Our ref: NO/2025/117140/03-L01
Your ref: 3/2025/0873
Date: 06 March 2026

**CONSTRUCTION OF 6 DETACHED DWELLINGS WITH ASSOCIATED PARKING
AND LANDSCAPING AT LAND OFF SPRINGWOOD DRIVE.**

LAND AT SPRINGWOOD DRIVE, WHALLEY, BB7 9XL

Environment Agency position

Drawing Title			
EXISTING TOPOGRAPHIC SITE PLAN			
Drawn by PD		Checked by	Date 04.02.26
Suitability S2		Scale @ A1	1 : 250
12477	SWD-CAA-ZZ-ZZ-D-A-1005	P6	
C+A JOB NO.	PROJECT - ORIGINATOR - VOL. - LEVEL - TYPE - ROLE - NUMBER	REV.

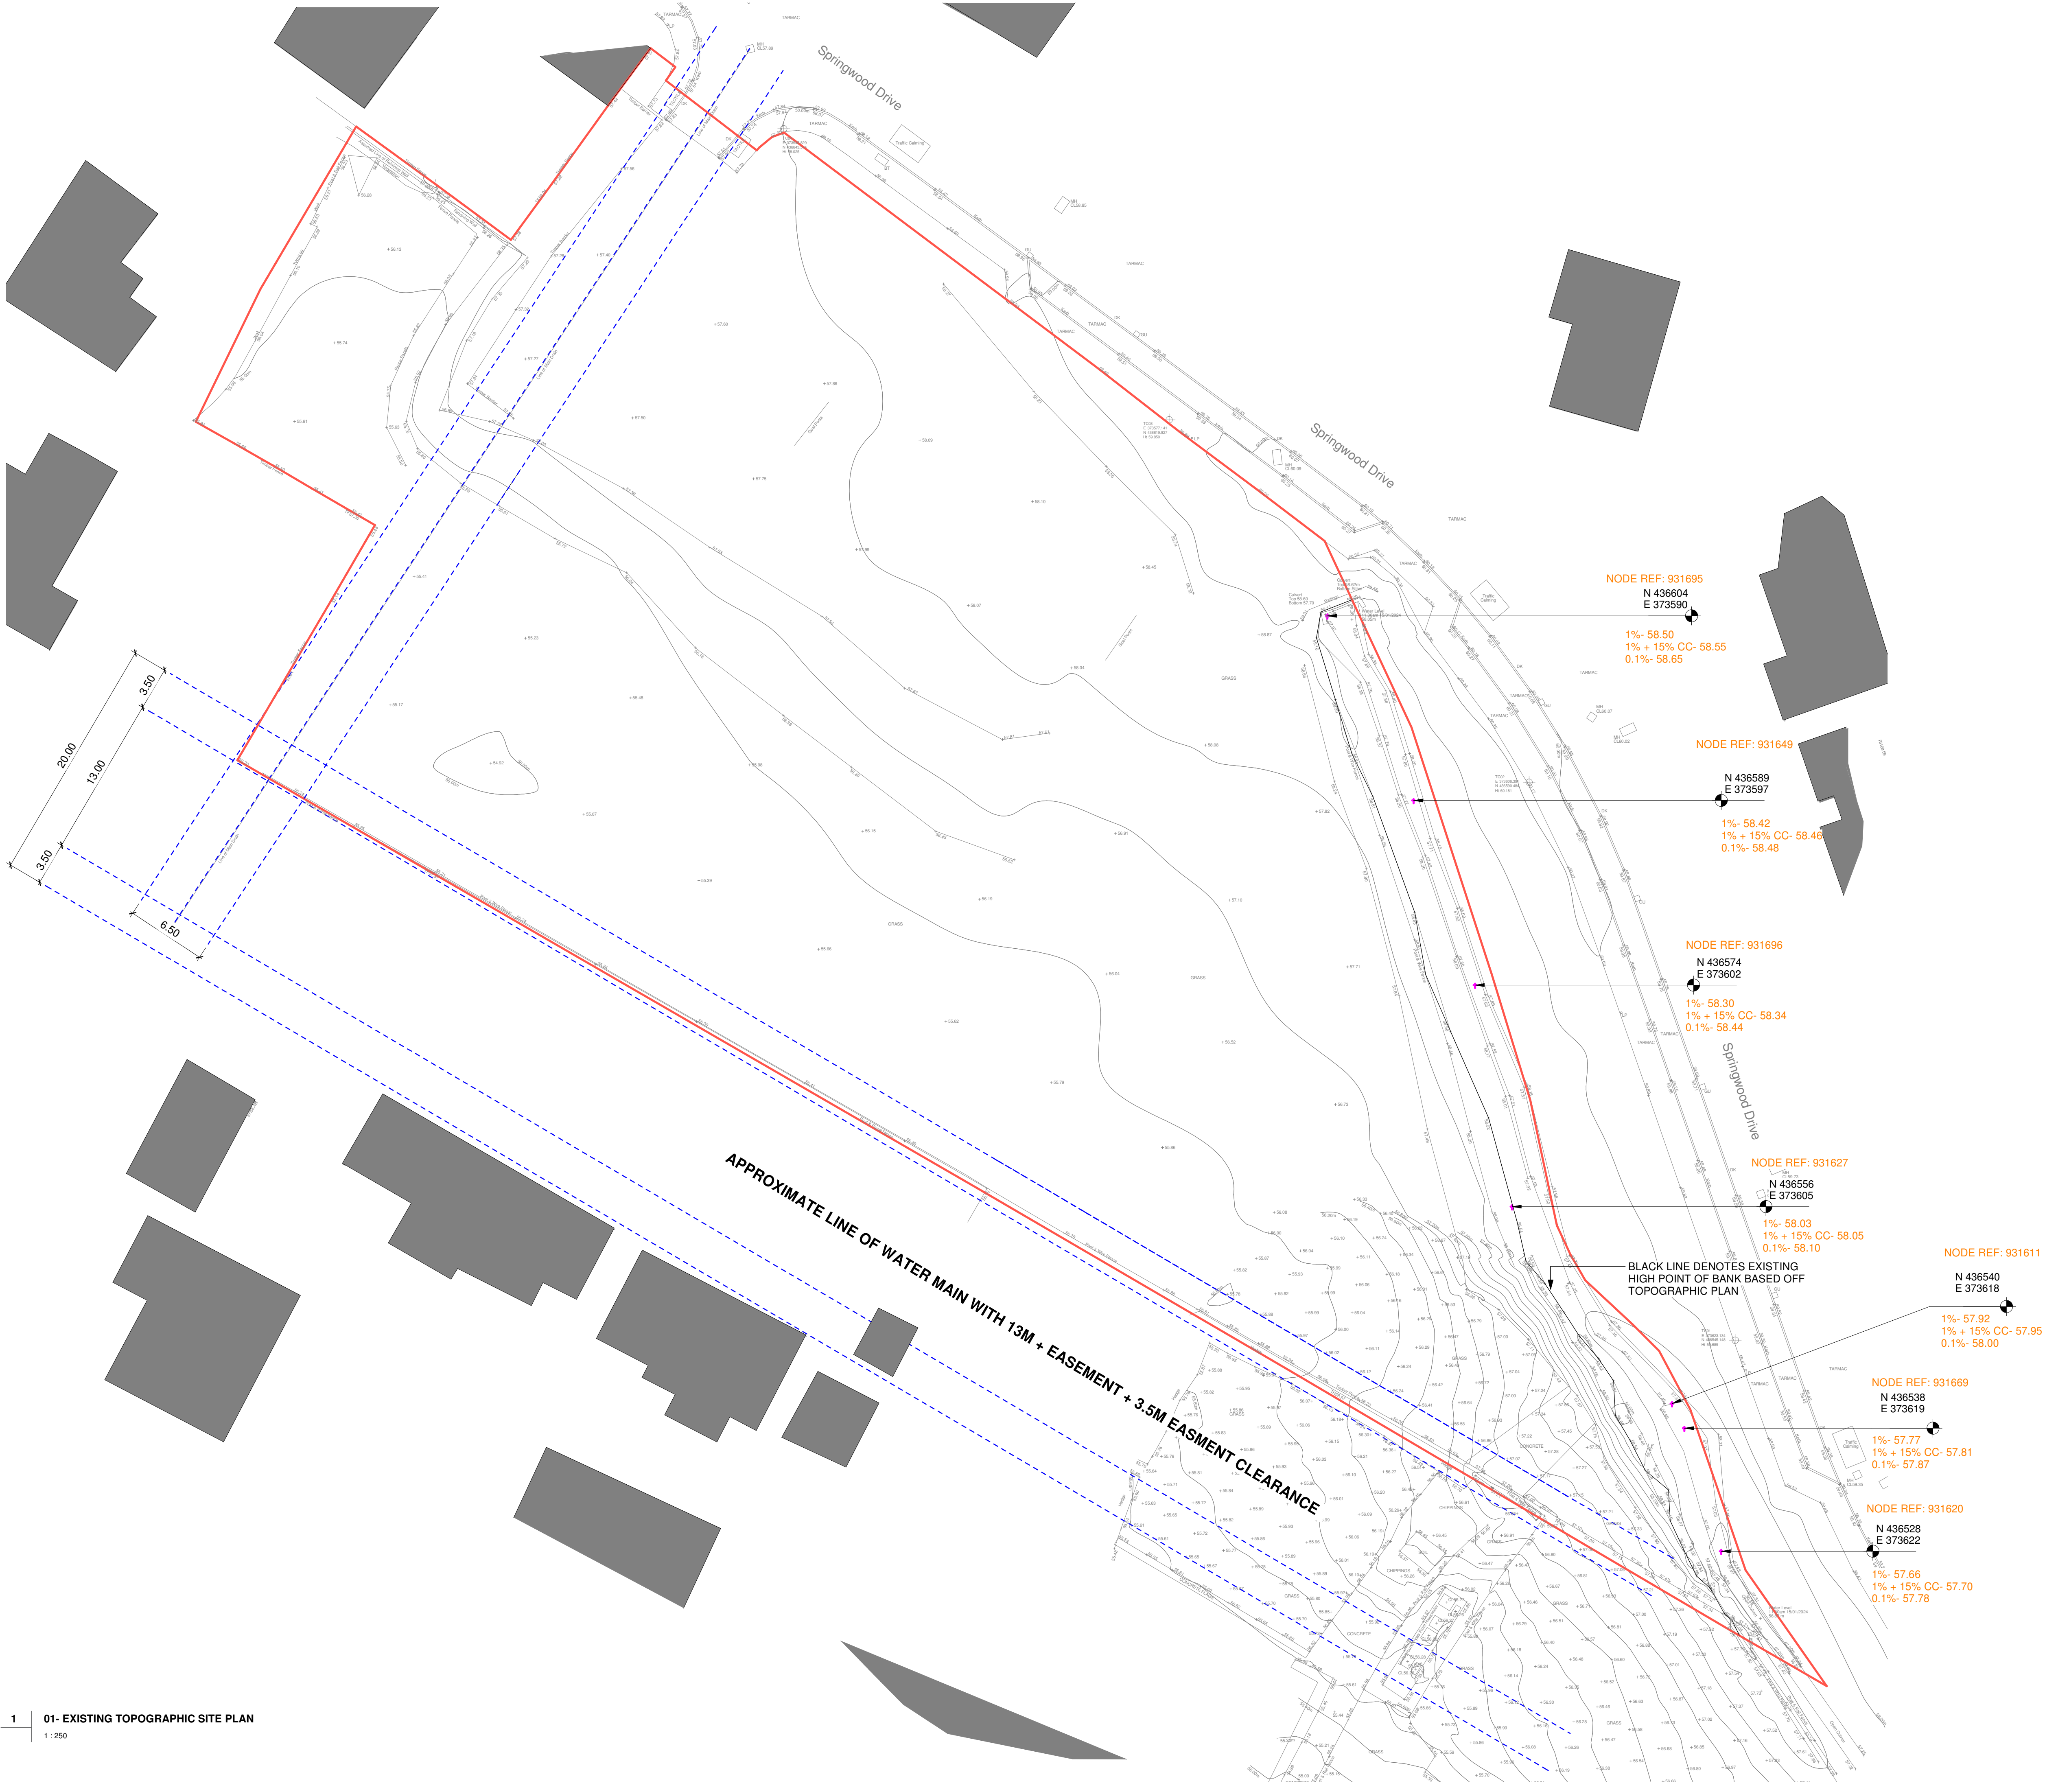
It is unclear whether the “Proposed Topographic Site Plan” (Drawing No.: SWD-CAA-ZZ-ZZ-D-A-1005, Revision: P1, Date: 04/02/2026) is indeed showing the proposed, or existing topo because it is overlayed on the existing site plan. We presume it is a typo and is actually showing the existing survey. Provide an appropriate proposed topographic survey (e.g. using contour lines with 200mm intervals), demonstrating how levels are proposed to change. The proposed topo should continuous maximum levels for the proposed retaining wall/upstand to aid the Flood Risk Assessment (such levels

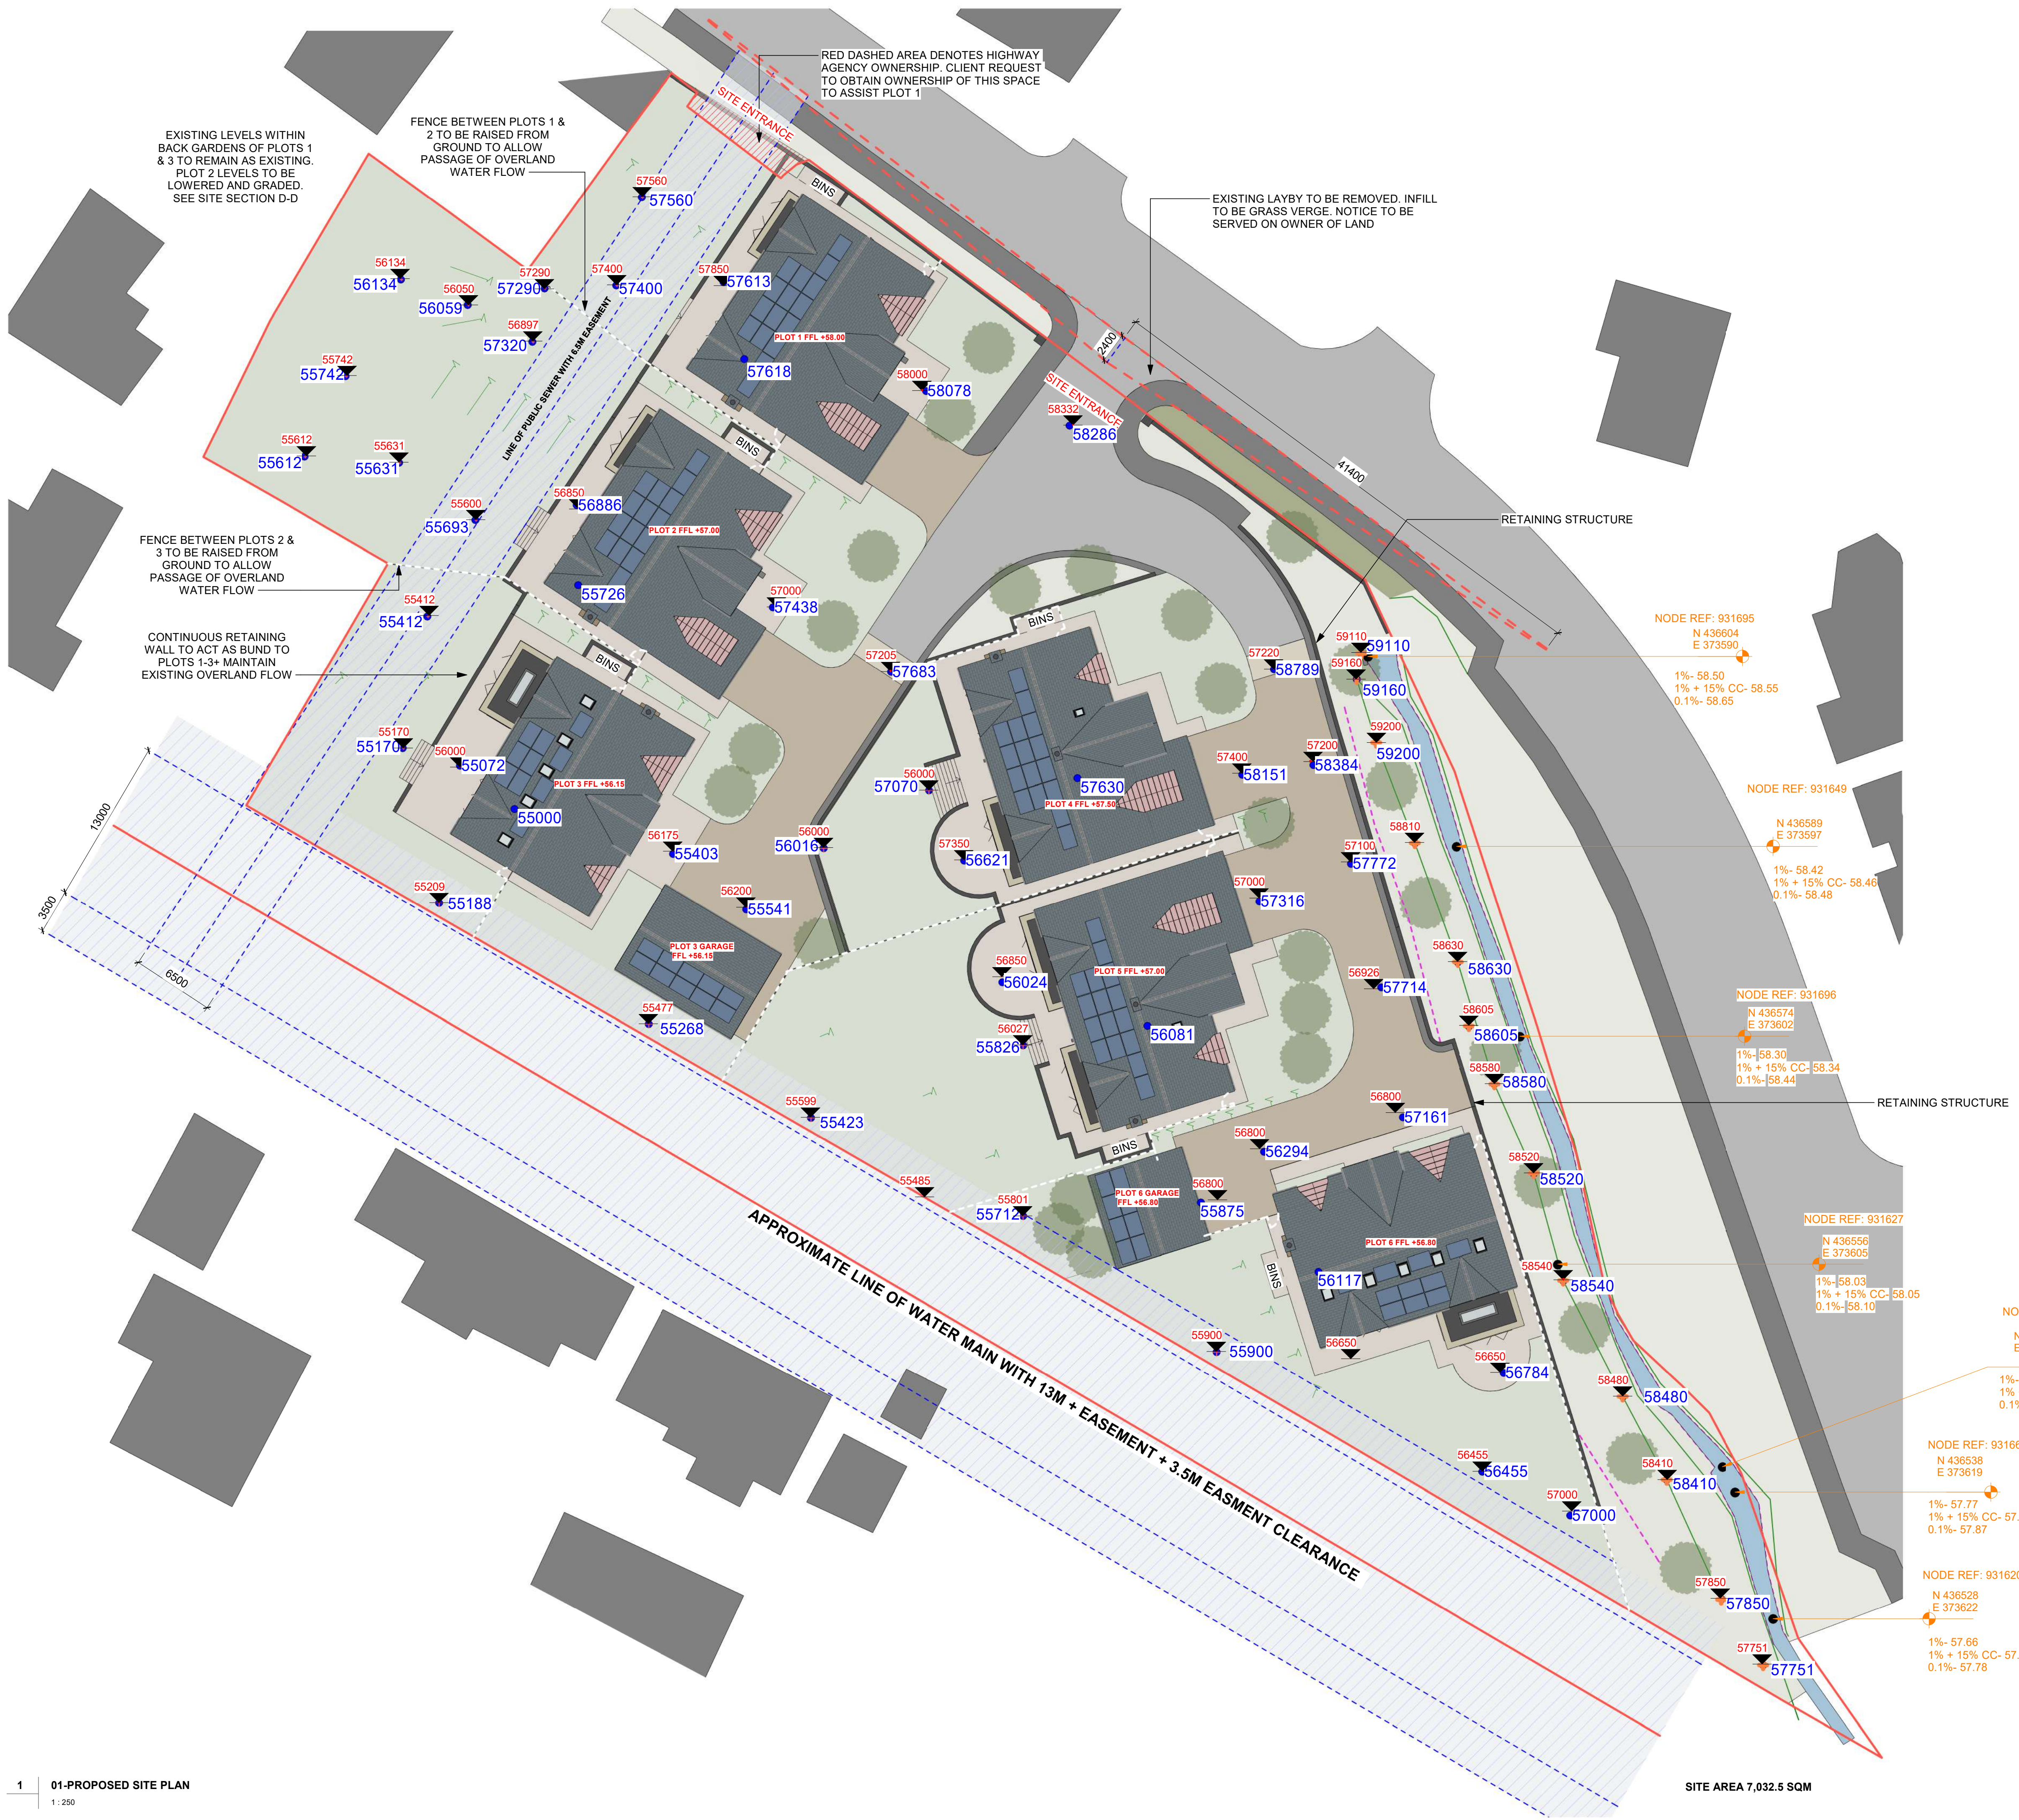
Section 6.16 of the updated FRA states “a retaining wall is to be installed inside the development site parallel to the western bank of the Wiswell Brook with an upstand of minimum 300mm height to prevent the site from flooding should water levels within the Wiswell Brook breach the western bank” – the proposal is corroborated by Section B-B from drawing No.: SWD-CAA-ZZ-ZZ-D-A-1004 (Rev: P4, Date: 08/01/2025). We understand that some management of the perched riverbank may be necessary (i.e. ensuring stability/structural integrity to manage any residual flood risk) – however, management which involves ground level raising (with the construction of a retaining wall with upstand) must not increase flood risk elsewhere – demonstration to this effect must be provided (this is imperative if the site floods in the design event, as shown by EA modelling). Further sectional drawings, with appropriate engineering details (e.g. maximum height of retaining walls of upstands), should be provided to aid the demonstration.

could be incorporated into the Proposed Site and Roof Plan of appendix D).
